# PORTLAND MAINE

July 16, 2009

Re: 116 Sheridan Street – 013 J010 – R-6 – permit #09-0722 – illegal deck

116 Sheridan Street  
Site Plan

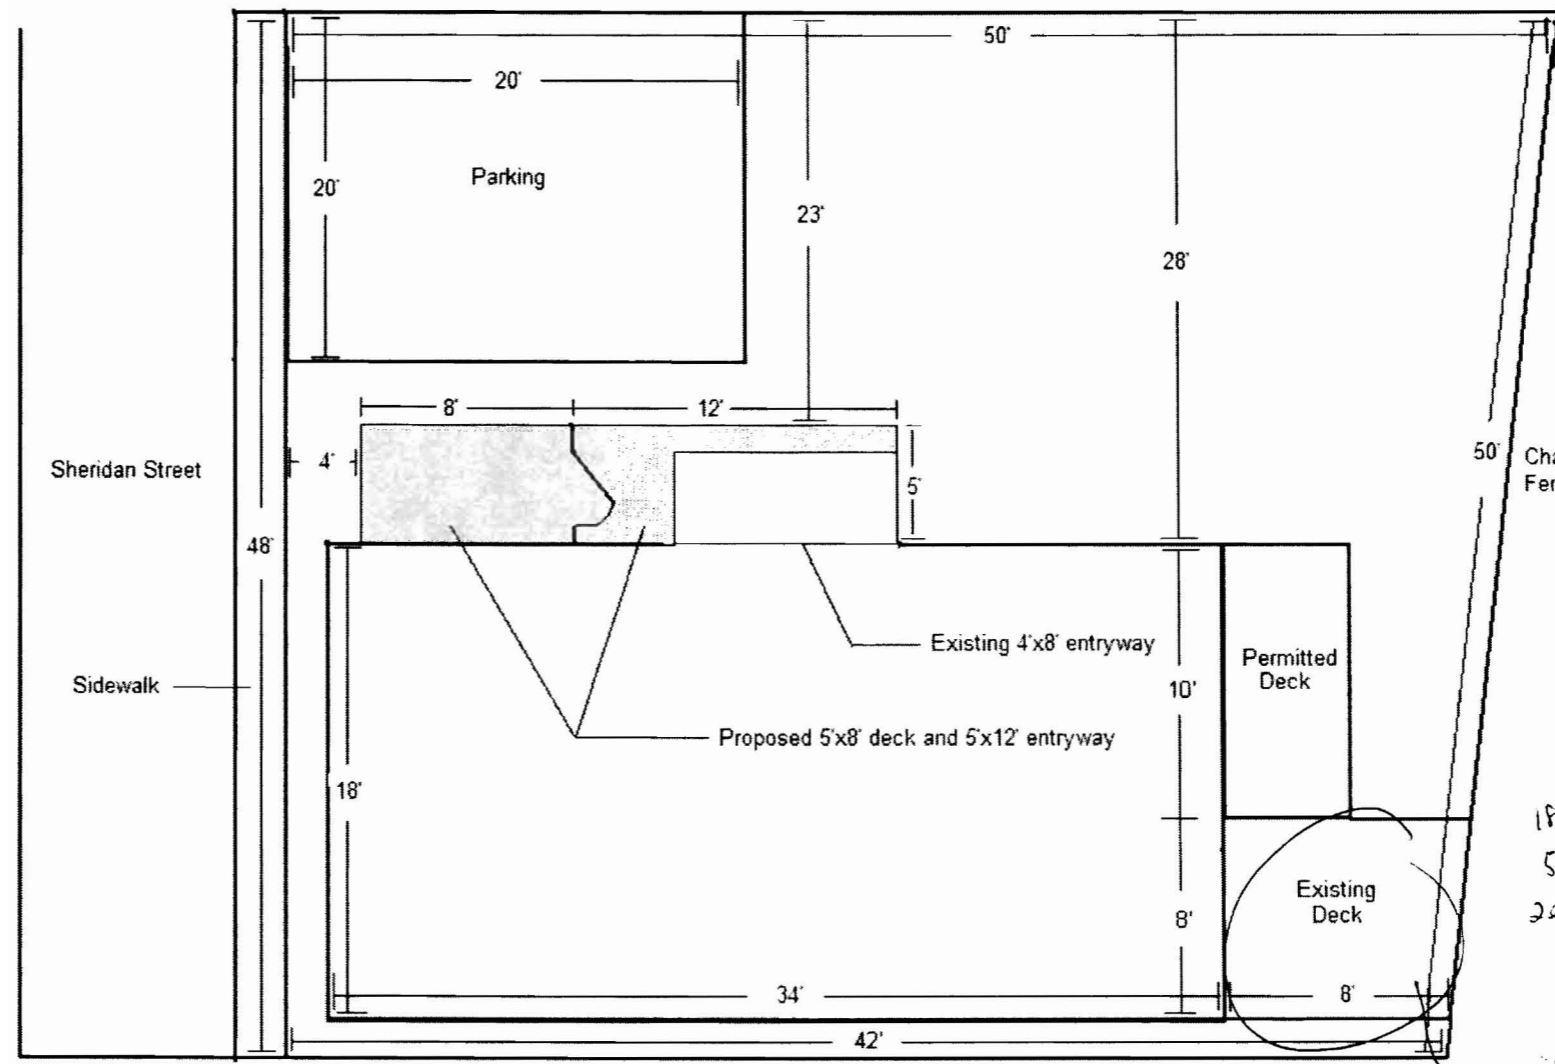
116 Sheridan Street is located in the R-6 residential zone. Section 14- 139(d)(2) gives the rear yard setback as twenty feet. Section 14-139(d)(3) gives the side yard setback as ten feet. The existing house does not meet the rear or side setback, but my research shows that the main part of the house (18' x 24') and the rear one story addition (5' x 10') were permitted prior to 1957. There is no record though of the 8' x 8' rear deck being permitted. The plot plan shows it being located right up to the rear property line and one to two feet from the side property line. Since it is not permitted and it does not meet the setbacks, the deck is not legal and must be removed.
